333-E-28
Milton St.
Subdivision
Diversified Properties

Subject: Milton Street
Revised Plans

Gorrill-Palmer Consulting Engineers, Inc. has received comments relative to the above referenced project from Anthony Lombardo, P.E. For ease of review, the comments are presented, followed by our response.

Titcomb Associates
133 Gray Road
Falmouth, Maine 04105

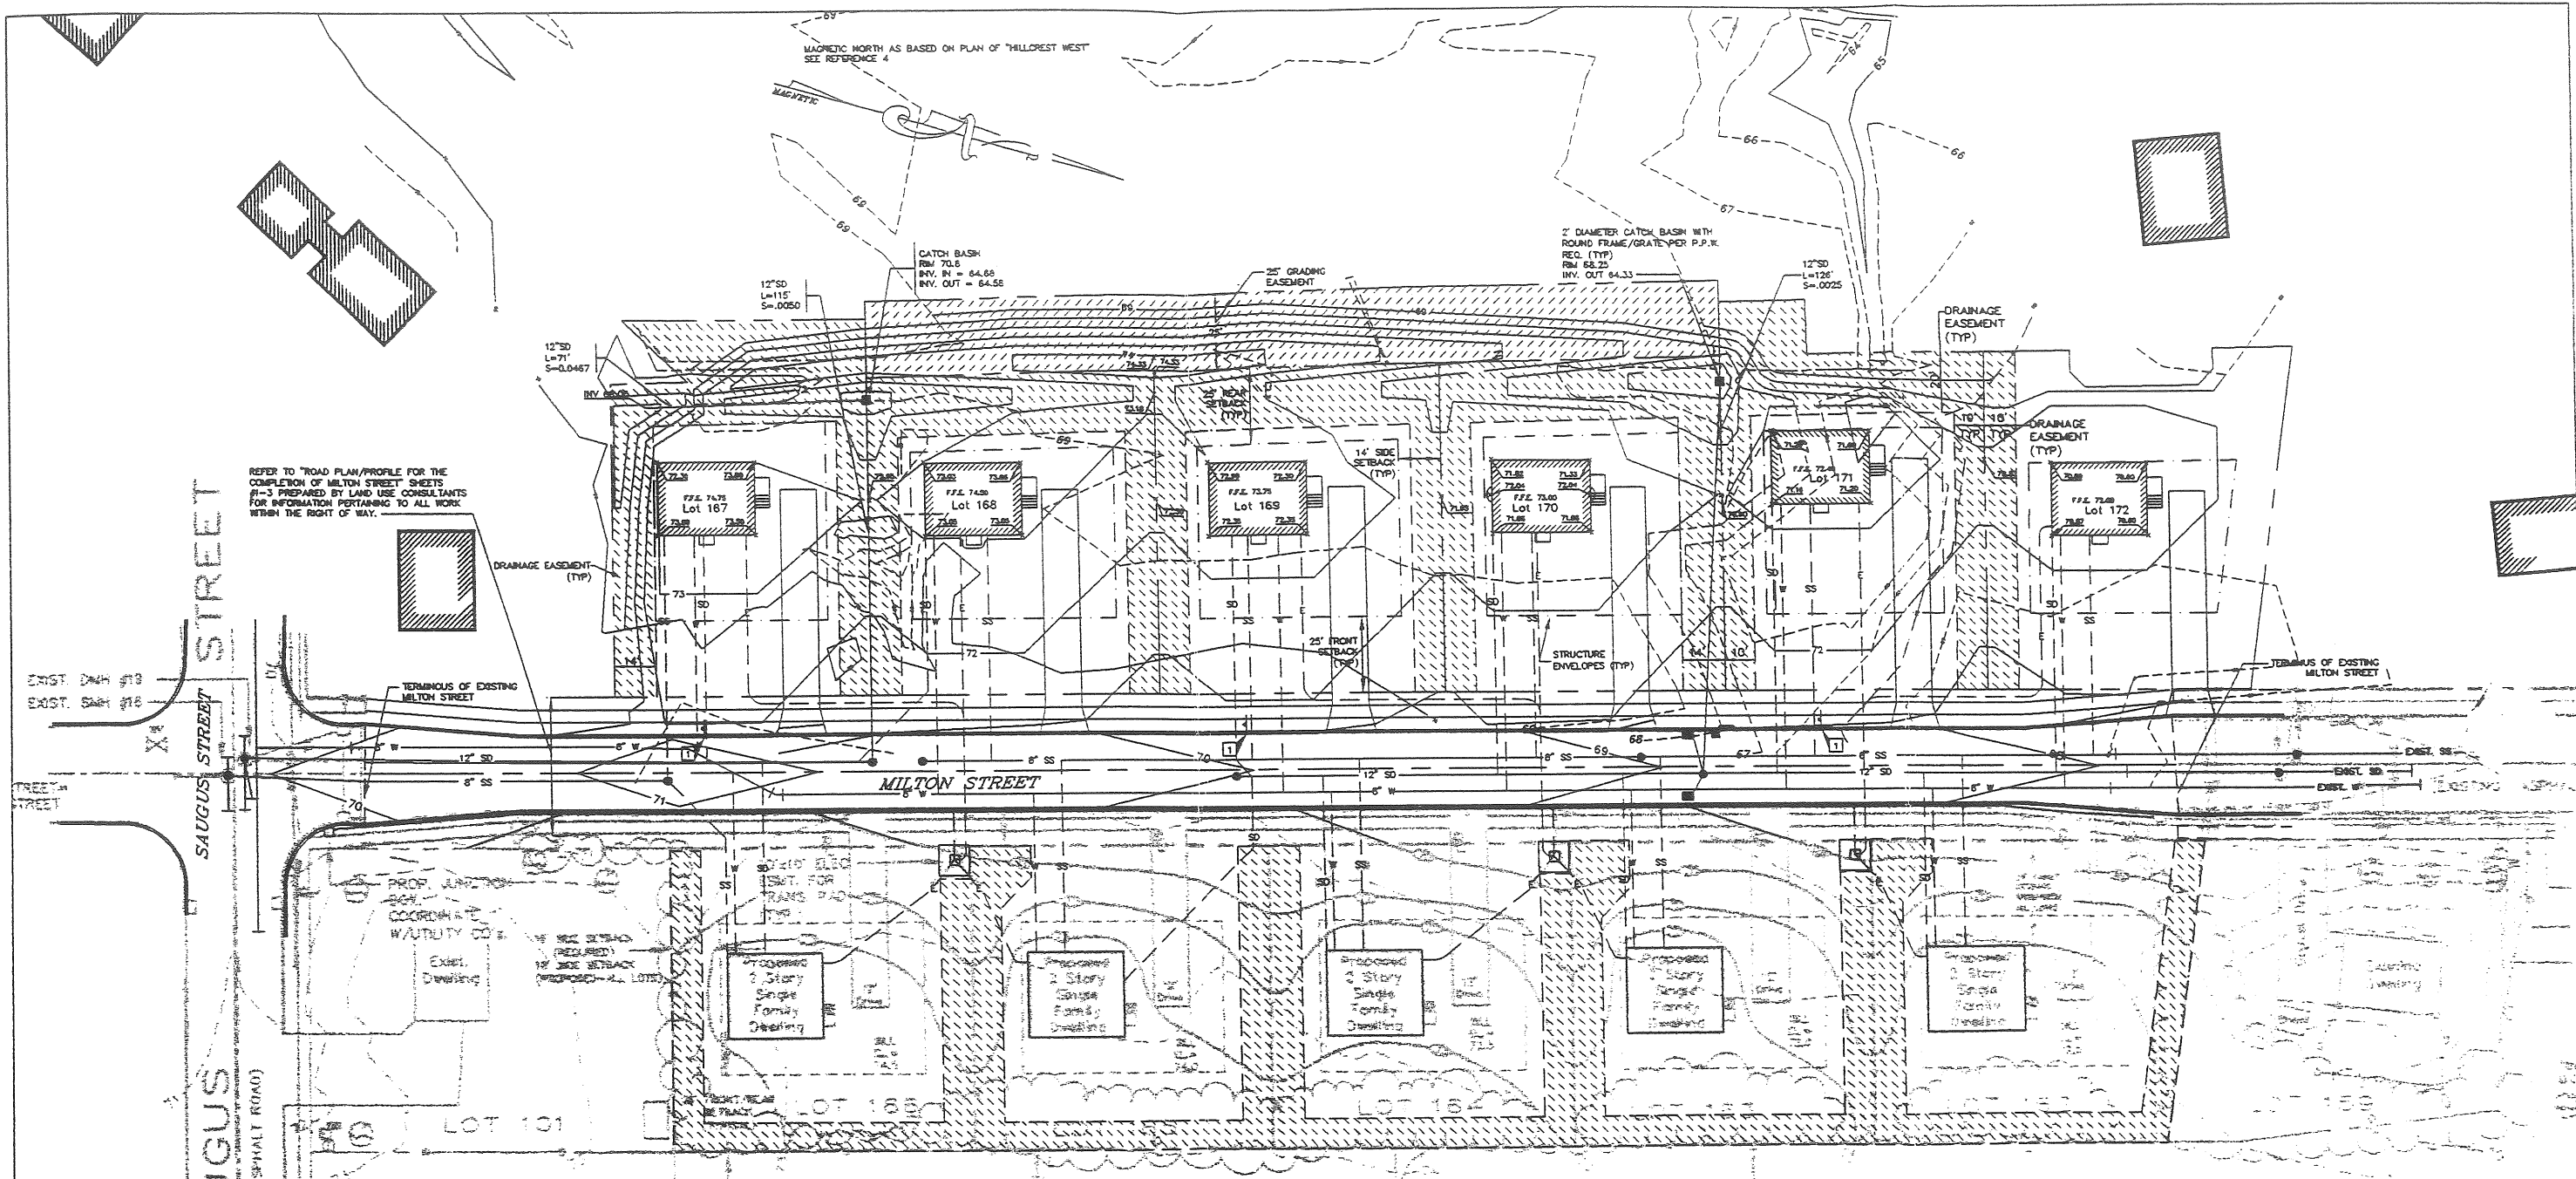
2. The subdivision plan shows no grading easement at the rear of the Germani property. This appears necessary based on the grading shown on the Gorrill-Palmer plan. The lot sizes shown on the subdivision plan also do not exactly match the Gorrill-Palmer plan. The differences are very minor i.e. 1 sf on three lots, probably due to computer rounding. However they should be corrected.

3. The subdivision plan shows a wetland across lots 167, 168, & 169. What is the status of the permitting for this wetland area. Also, is the entire wetland area shown since it appears the wetland limit line does not connect upon itself?

Drawing Name:	Conceptual Development Plan
Project:	MILTON STREET EXTENSION

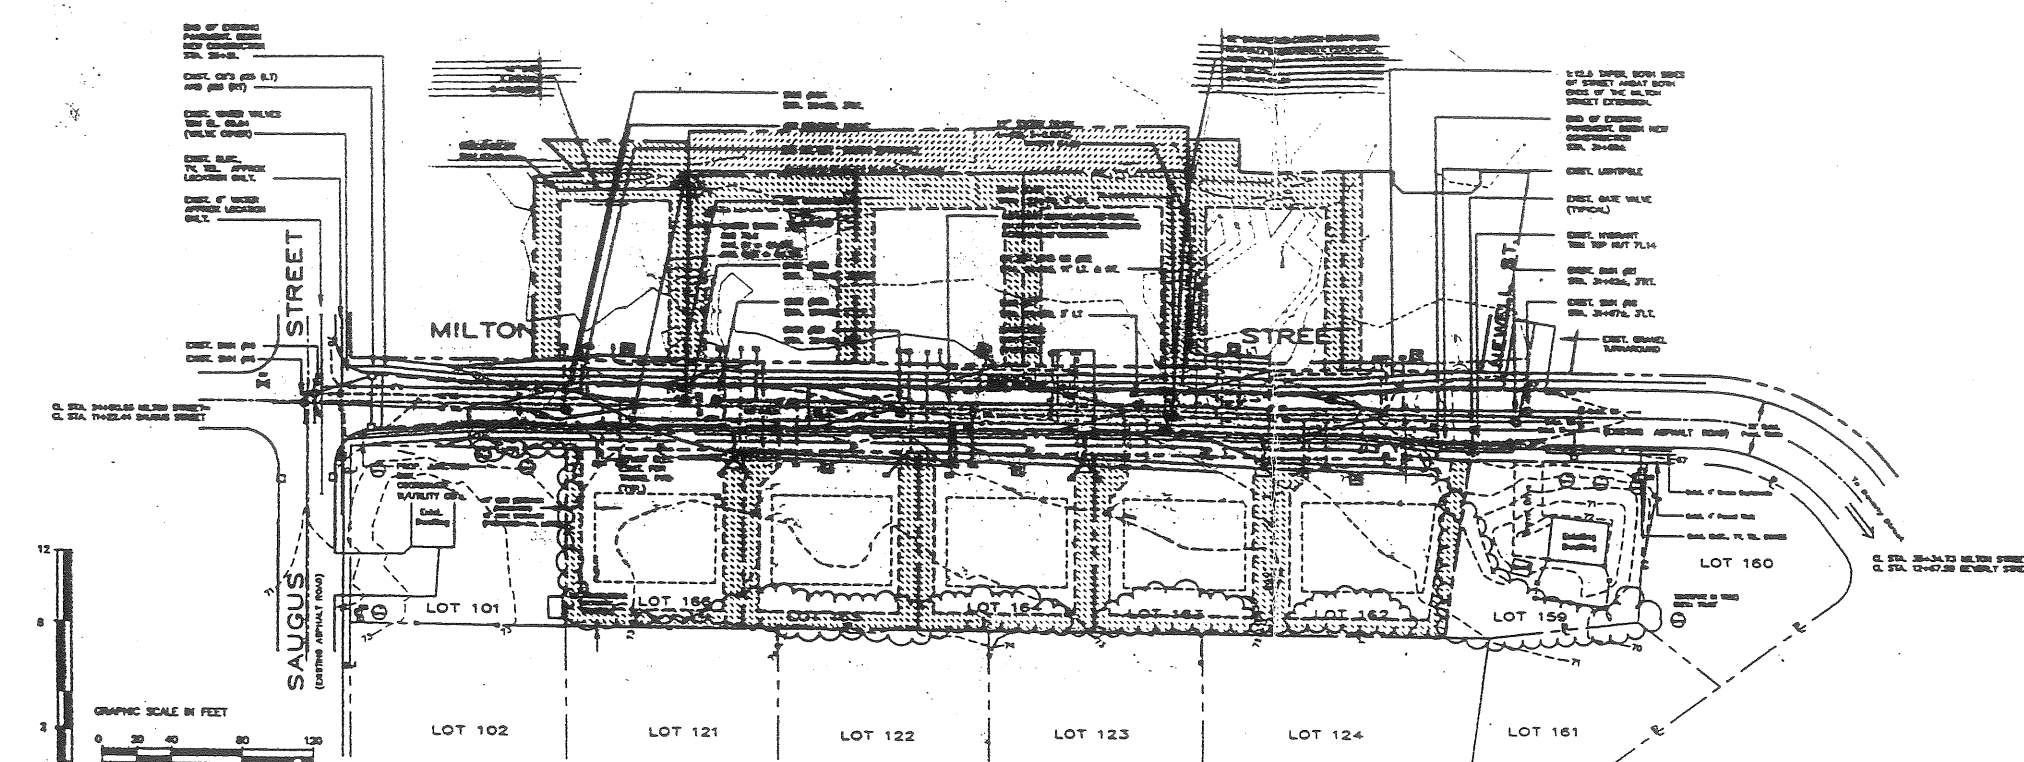
Comment 1 – Proposed Lots 165, 168 & 169 specify storm drain service connections directly into manhole structures. This appears on Sheet 5 “Conceptual Development Plan”. Public Works does not allow individual service connections into manholes and is requesting the applicant revise the plans to specify the storm drain service from Lot 168 to connect into the storm drain proposed along the southerly boundary of this lot. The services from Lots 165 & 169 should be connected into the storm drain main, in Milton Street, just ahead of the proposed manhole.

Response – The plans have been revised as requested. Seven sets of updated plans are enclosed.

TITLE:
ROAD PLAN/PROFILE
For the Completion of
MILTON STREET
Being a Portion of
WOODFORDS GARDENS
Portland, Maine

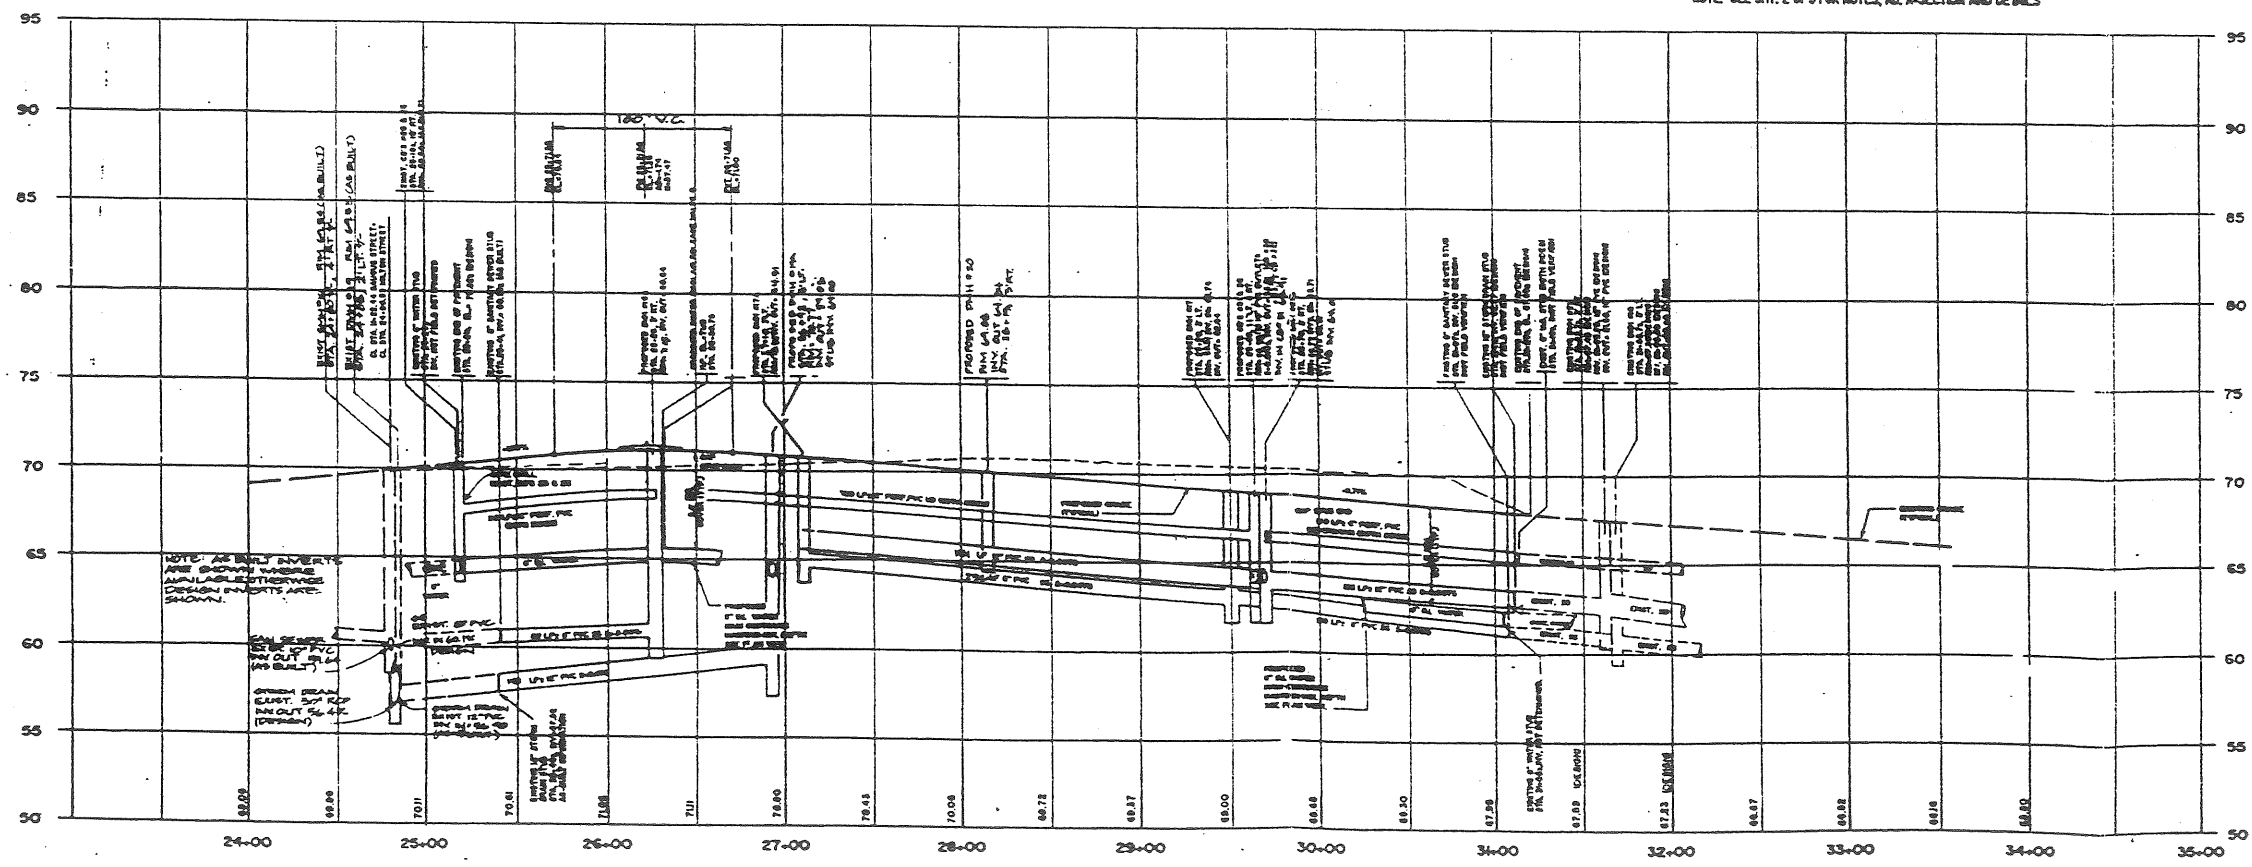
- The “Conceptual Development Plan” and the plan entitled “Road Plan/Profile for the completion of Milton Street” specify conflicting utility information. DMH-19 on the “Conceptual Plan” is labeled DMH-19A on the “Road Plan/Profile”. The “conceptual plan” proposes a storm drain connection into DMH-19 from Lots 167 & 168. The “road plan/profile” specifies only a stub section of pipe. The “conceptual plan” proposes a storm drain connection into CB-31 from Lots 170 & 171. The “road plan/profile”, instead, specifies a 12” diameter storm drain stub towards the center of Lot 171 and not towards the easement proposed between Lots 170& 171.

- The “road plan/profile” should also specify every storm drain and sanitary service from each proposed house lot. This is extremely useful in avoiding utility crossing conflicts.
